PPR2248

PROJECT INFORMATION		
Struthers Ranch Polaris - GEC	8/9/2022	
Project Name	Date	PCD File No.

# Financial Assurance Forms\_V1.pdf Markup Summary

**11 RETAINING WALL DTL (6'-0" TO 12'-0") HIGH**  
SCALE: 1/2"=1'-0"

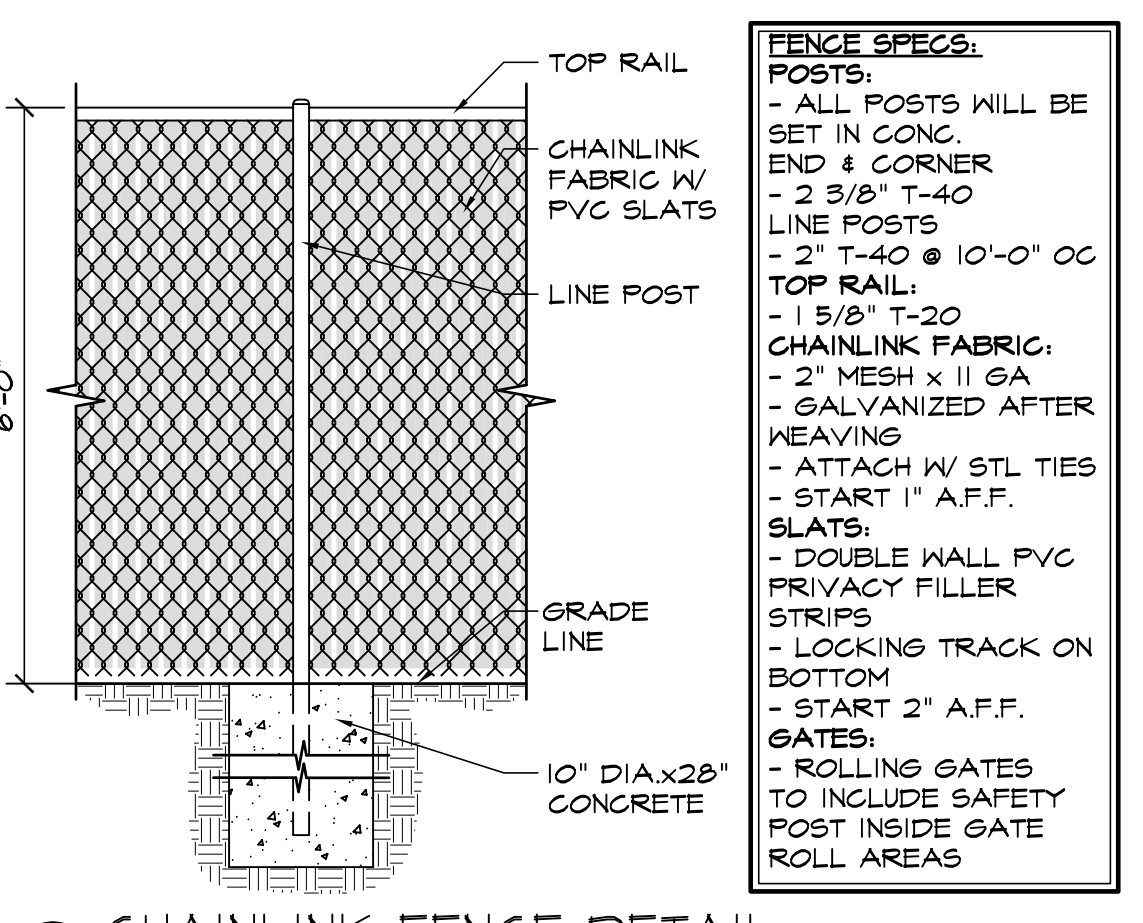
Include a line item for the Pond retaining wall

**6 PEDESTRIAN RAMP DETAIL D-BJ**  
SCALE: 3/16"=1'-0"

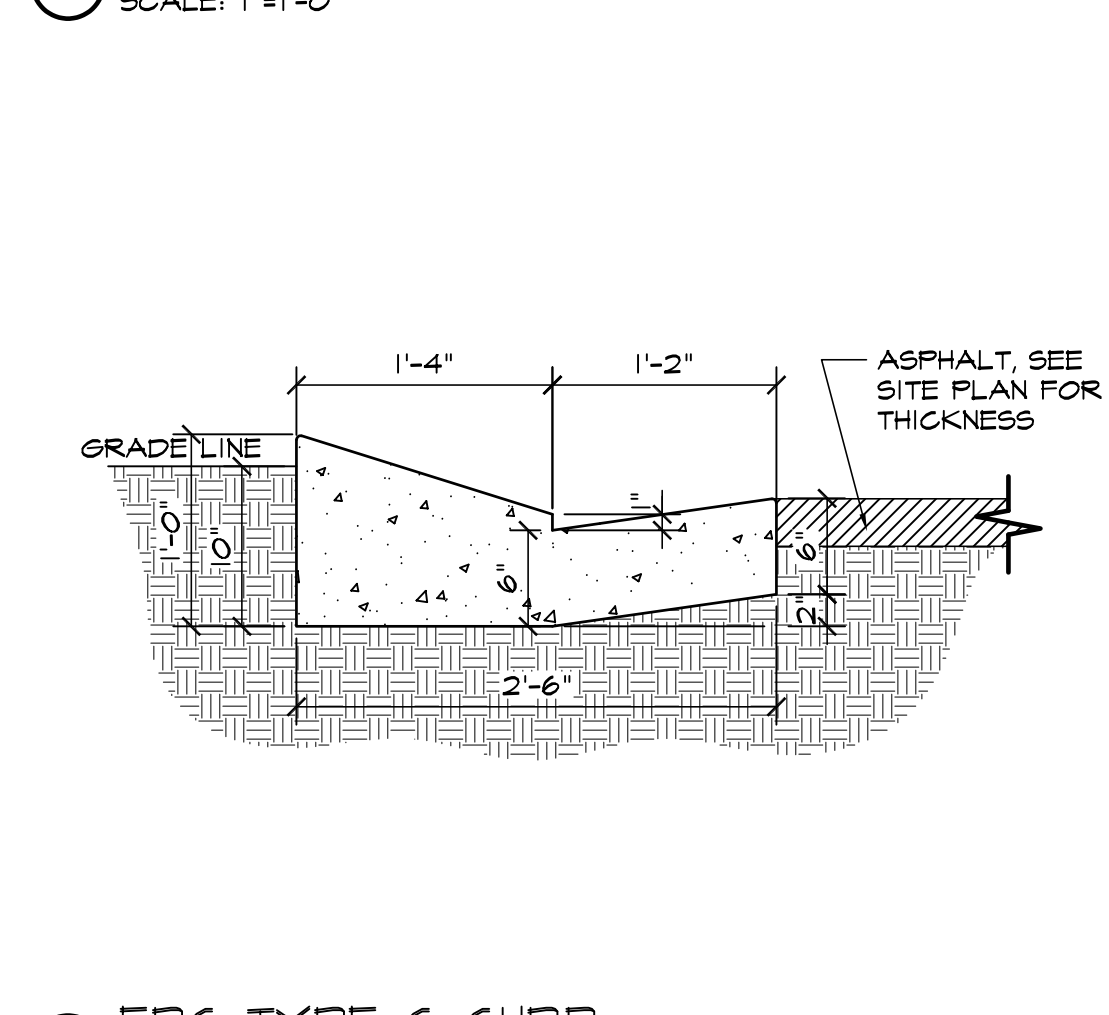
Provide quantity for the two proposed ramps at the driveway access.
